RE: Review of landscape Plan – Proposed Industrial Development 431 (lot 32) Masonite Road, Heatherbrae

As discussed, this letter is to formally acknowledge a review of the landscape plan that forms part of a Part 3A application for the above site. The plans reviewed were Drawings A22 – 25 (rev 08, dated 24 June 2010), prepared by Geoff Craig and Associates on behalf of Sandvik. The plan was reviewed by myself, a Registered Landscape Architect (no. 719).

DWG A23

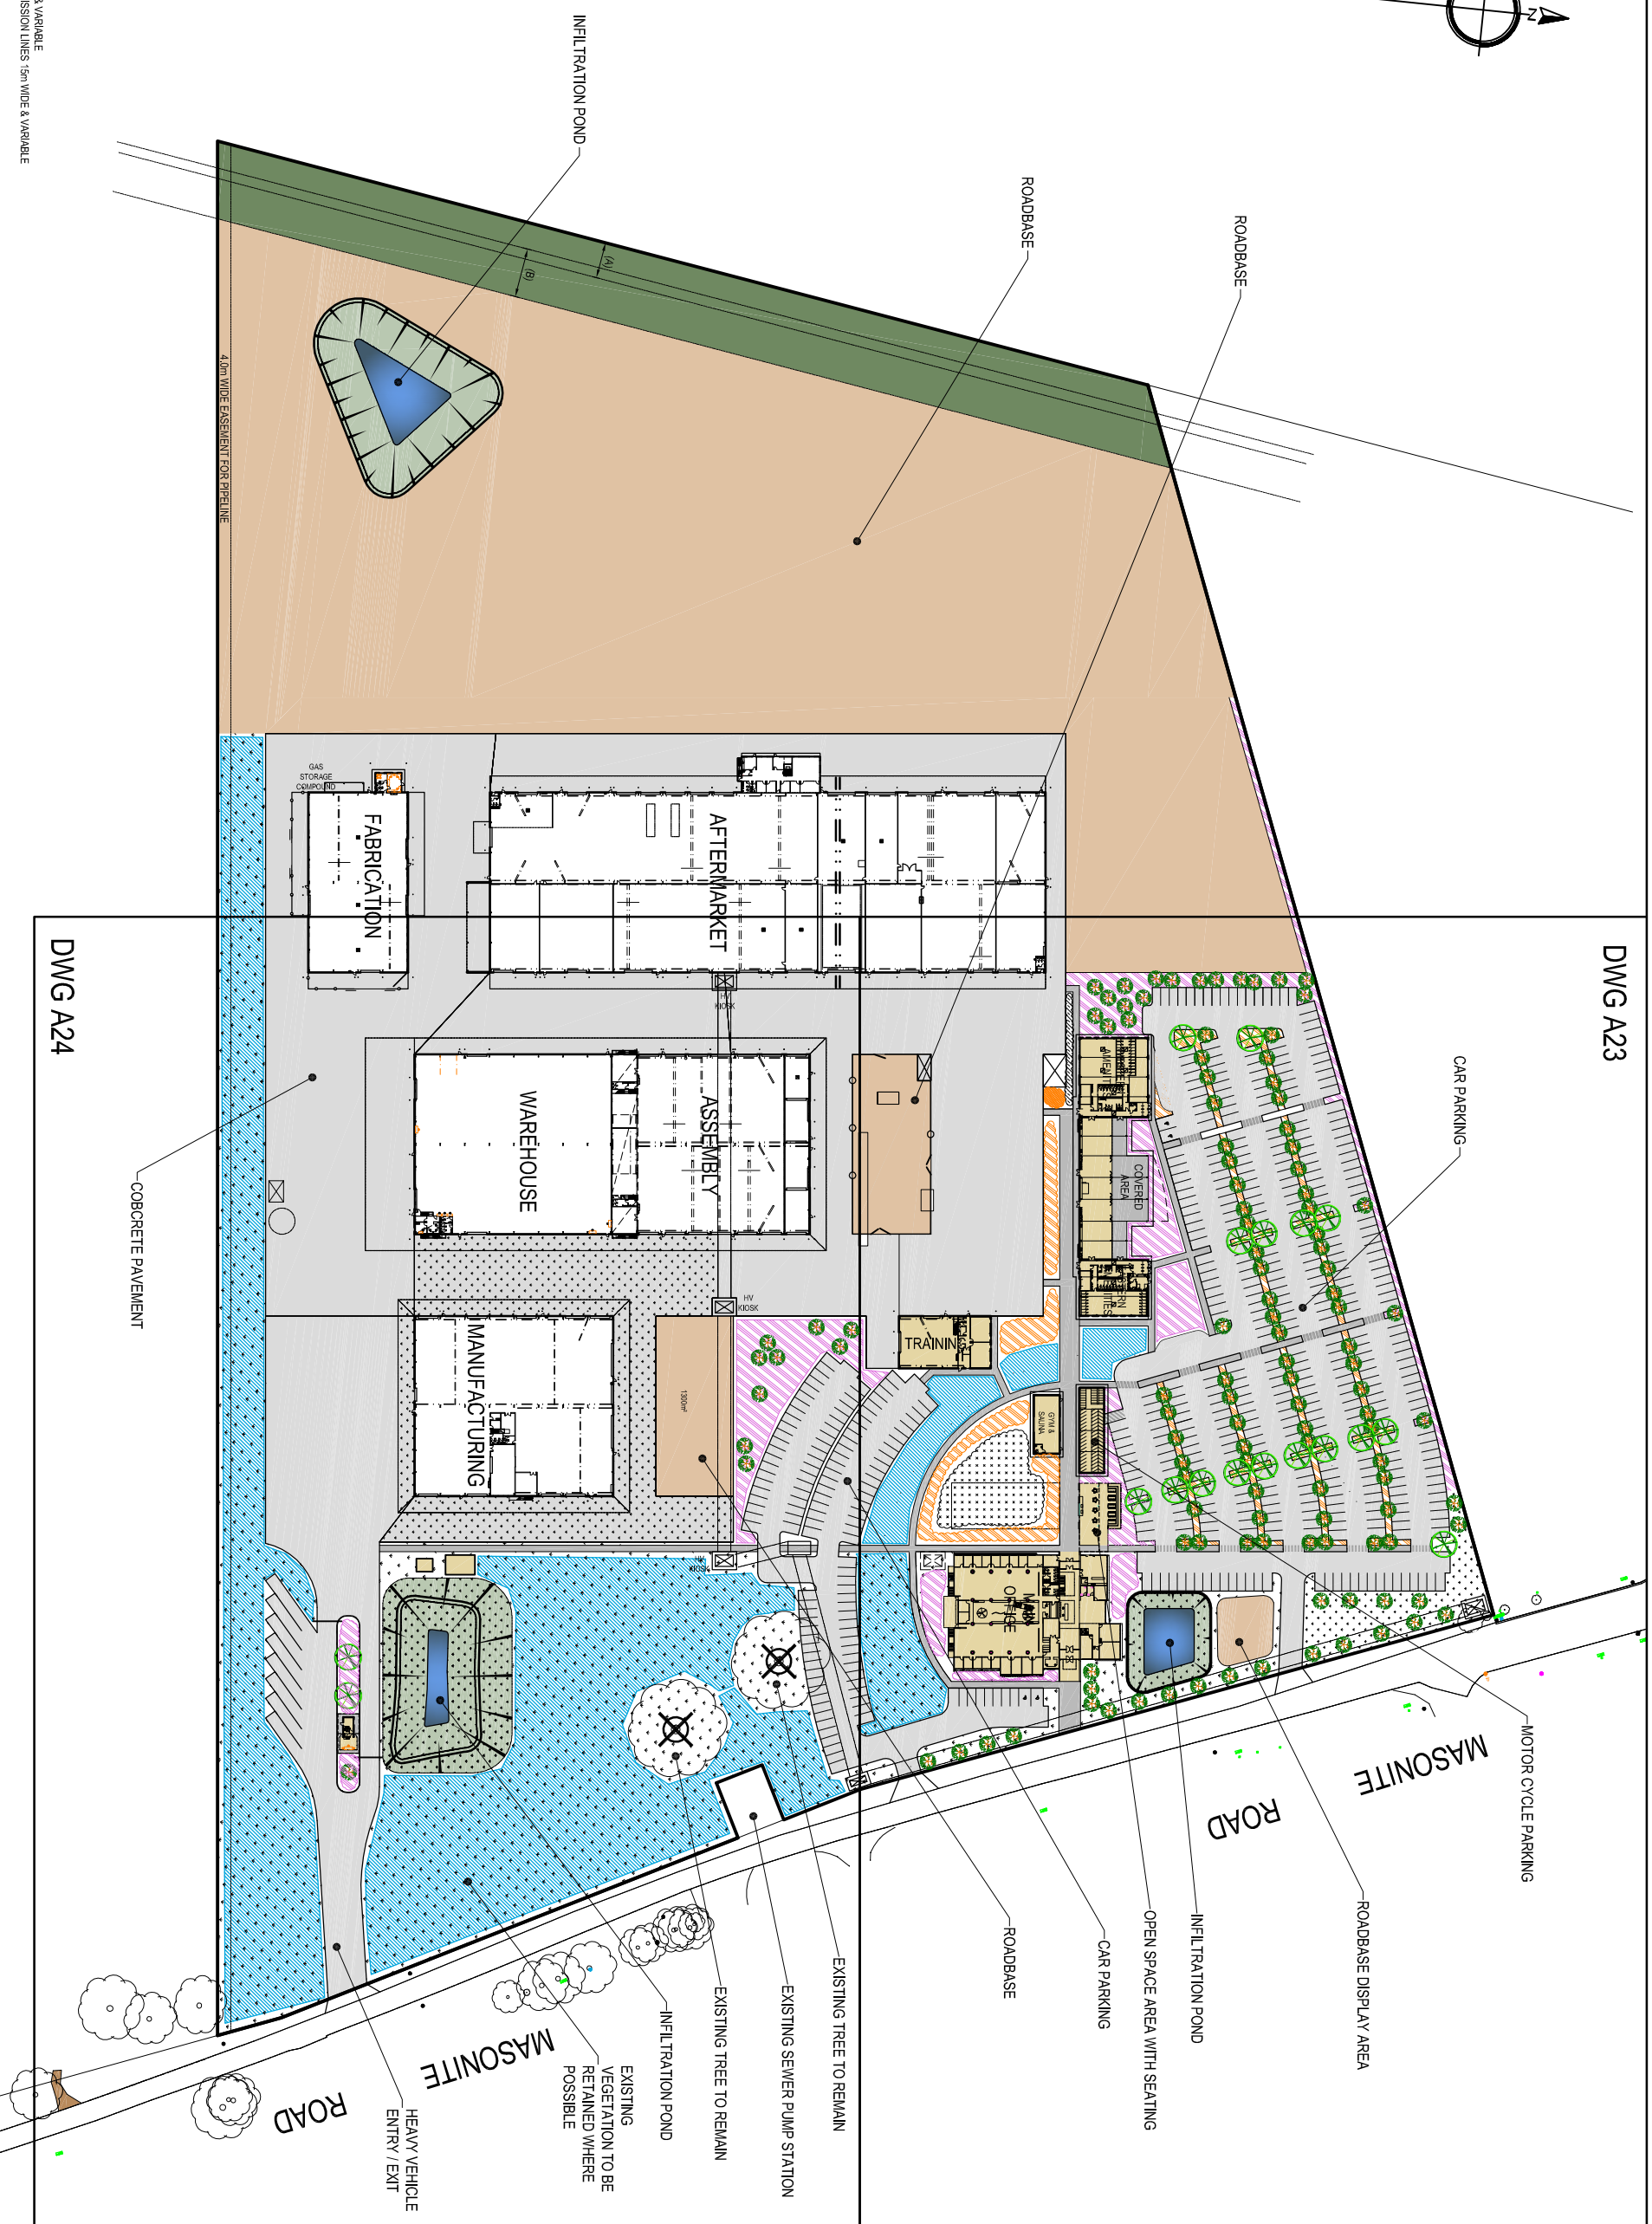
- During the next stage attention is directed towards conserving as much of the on-site vegetation as possible. To achieve this outcome levels around existing vegetation need to remain unaffected wherever possible and existing drainage patterns that affect existing vegetation should be kept as close as possible to the natural patterns.
- Weed management of vegetation areas to be retained should be undertaken.
- Infiltration ponds should be appropriately landscaped.
